COMMUNITY DEVELOPMENT DEPARTMENT
80 Columbia Avenue ♦ Marysville, WA 98270
(360) 363-8100 ♦ (360) 651-5099 FAX

Re: PA22-010 Sunnyside Nursery Expansion
Cc: Chris Holland, Angela Gemmer

Your application has been further reviewed. Below are our revised comments:

SUNNYSIDE SOUTH PRELIMINARY SITE PLAN

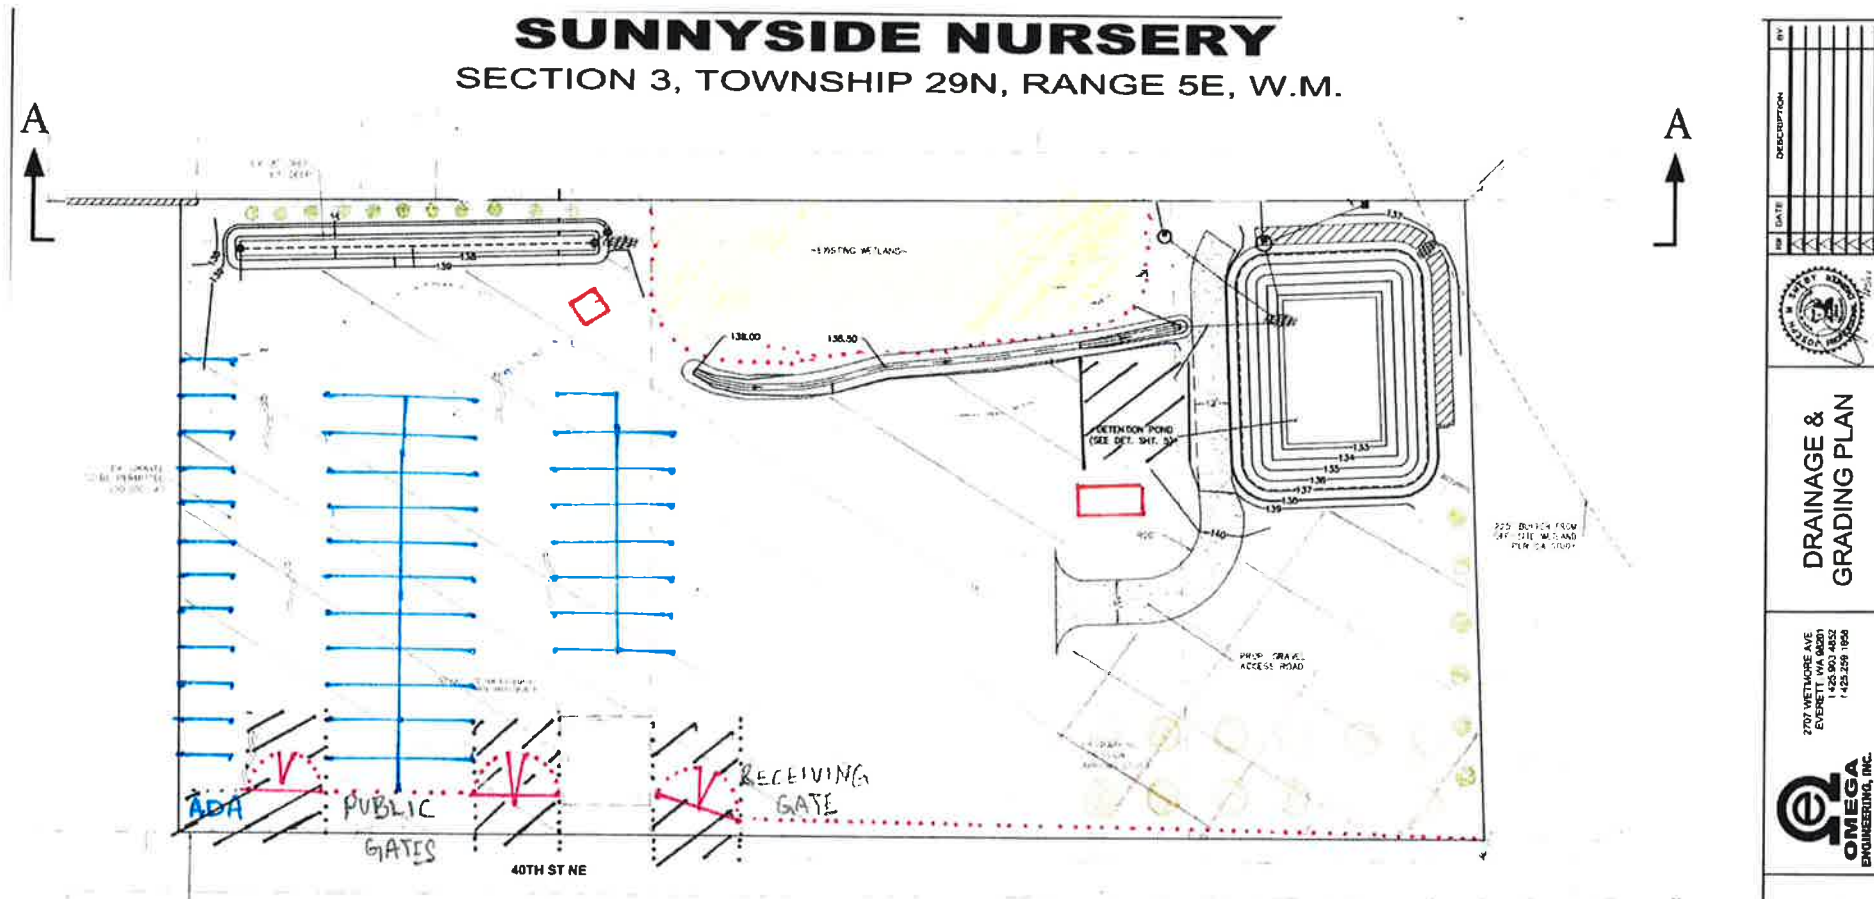
- Provide 20 feet of asphalt pavement at the entry/exit(s) of the parking lot.
- For landscape screening, you may choose to either plant a landscape buffer on the north, east & south property lines; **OR**, you can choose to designate a fixed area for storage of non-vegetation stock and screen the storage area only. If you choose the latter, provide:

- Provide a 5 foot landscape buffer along the north side of the property (exclusive of the completed wetland mitigation area).
 - Provide a 5 foot buffer on the property lines adjacent to the detention pond and storage areas.

- The required 15-foot buffer on the south side may be reduced 25% to 11.25 feet.
 - The buffers adjacent to the storage areas
- No landscape screening is required on the west property line.

- No parking lot illumination required.
- Submit a revised civil site plan from your engineer showing proposed fencing and landscape buffers and widths, method of irrigation, and parking stalls.
